**Maritime and Coastguard Agency**  
UK Technical Services Navigation  
105 Commercial Road  
Southampton  
SO15 1EG

[www.gov.uk/mca](http://www.gov.uk/mca)  
20 February 2024

### **Application by Equinor New Energy Limited (“the Applicant”) for an Order granting Development Consent for the proposed Sheringham Shoal and Dudgeon Offshore Wind Farm Extension Projects (“Sheringham and Dudgeon Extension Projects”)**

#### **Comments on the information provided in response to the Secretary of State’s request of 22 November 2023.**

Sheet 1 of 6

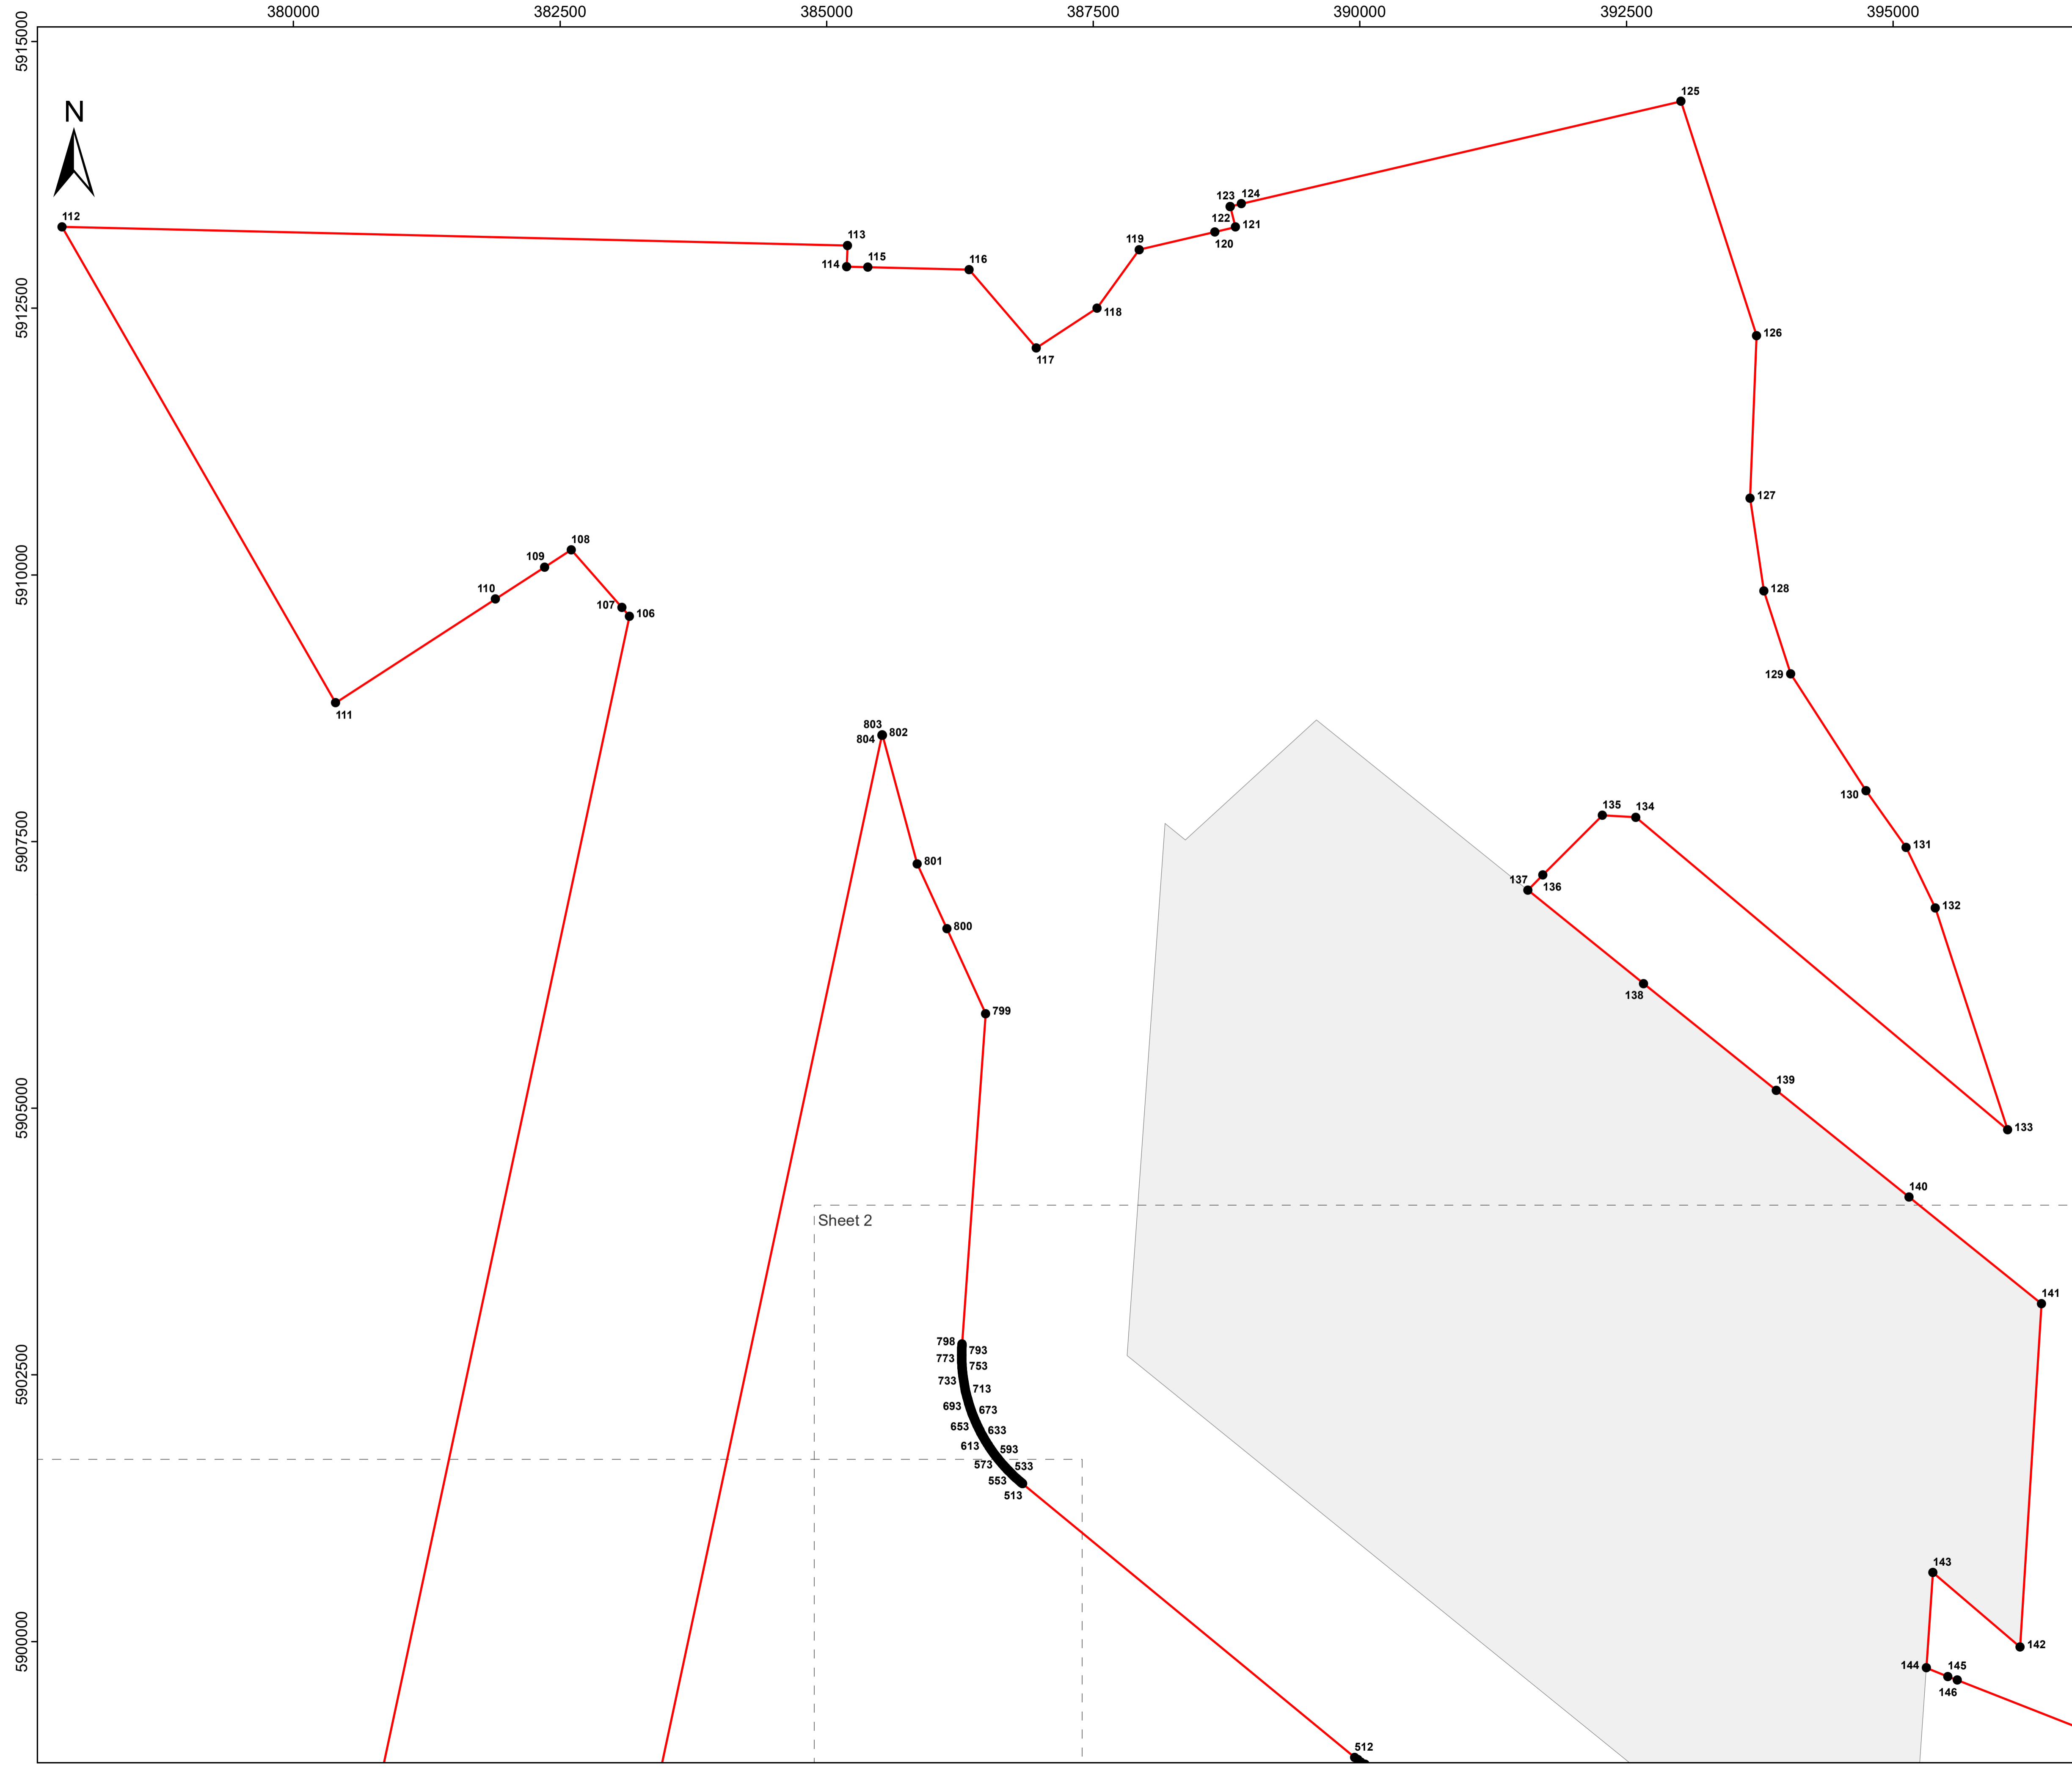
On review of the available information provided by the applicant, the controlling depth they use within the limits of the Outer Dowsing Channel is 10m, on the assumption the channel is taken from the navigational marks on the east to the extremities of the Triton Knoll windfarm (Figure 4). This is using a very narrow and specific interpretation of the definition as stated within the Mariner's Handbook rather than the wider principle as applied in vessel navigation decision making and is based on an assessment where the traffic data is not considered. It is clear from Figure 6 that vessels transiting the area do not use 10m as the controlling depth but are maintaining the 15m contour and therefore at the critical juncture west of DEP-North, the 15.3m wreck is the natural controlling depth.

The AIS data provided by the applicant (Figure 6) indicates that most vessels maintain a distance of approximately 0.8nm from the Mid Outer Dowsing lateral buoy and Dudgeon west cardinal buoy as well as a similar distance to the 15.3m wreck and shallow patch to the west. The applicant has assessed post installation routing within their NRA and has stated that it is not expected that the proposed DEP-North site will affect vessel routing, therefore potentially acknowledging that mariners will continue to utilise the 15.3m wreck and 15m contour as the controlling depth. What is not assessed or acknowledged fully within this section of the NRA is the potential increased collision risk caused by the reduction of sea room if transiting vessels do not reassess routes and waypoints to base their controlling depth on 10m, which has been used as the basis for the applicant's ALARP assessment. On analysis of the current traffic movements, traffic routes, and utilising the applicant's NRA in relation to post installation expectations, it is

the opinion of the MCA that there is a potential for increased collision risk due to the reduction of available sea room which we believe has not been adequately assessed within the NRA and no clear mitigation identified. Given the likely squeeze of traffic when safe passing distances are applied, MCA's assessment was that vessels will be constricted into a route 1.3NM wide which, given the high collision risk already present in the area, we believe to be insufficient. The narrowing of the channel will increase the frequency of encountering head on situations and merging traffic and will limit mariners' options for taking early and substantial avoiding action if a collision scenario is identified. This in turn increases the risks of collision with the turbines and grounding on nearby shallow banks.

Therefore, the appropriate mitigation as per our Deadline 7 and 8 submissions on 6 July 2023 and 17 July 2023 respectively, is either a reduction in the Red Line Boundary to a line joining the Mid Outer Dowsing lateral buoy and Dudgeon west cardinal buoy, or a commitment to not construct any structures in the hatched area in Figure 7 which would provide a 3.2NM width of sea room measured from the 15.3m wreck and the buoy-to-buoy line. In this regard, and in reference to the applicant's assertion that our position is contrary to Trinity House's position, it is noted that Trinity House confirmed at Deadline 5 that they "would defer to the MCA, as the primary navigational safety body, when defining shipping routes/lanes and assessing the appropriate widths of corridors as per MGN654".
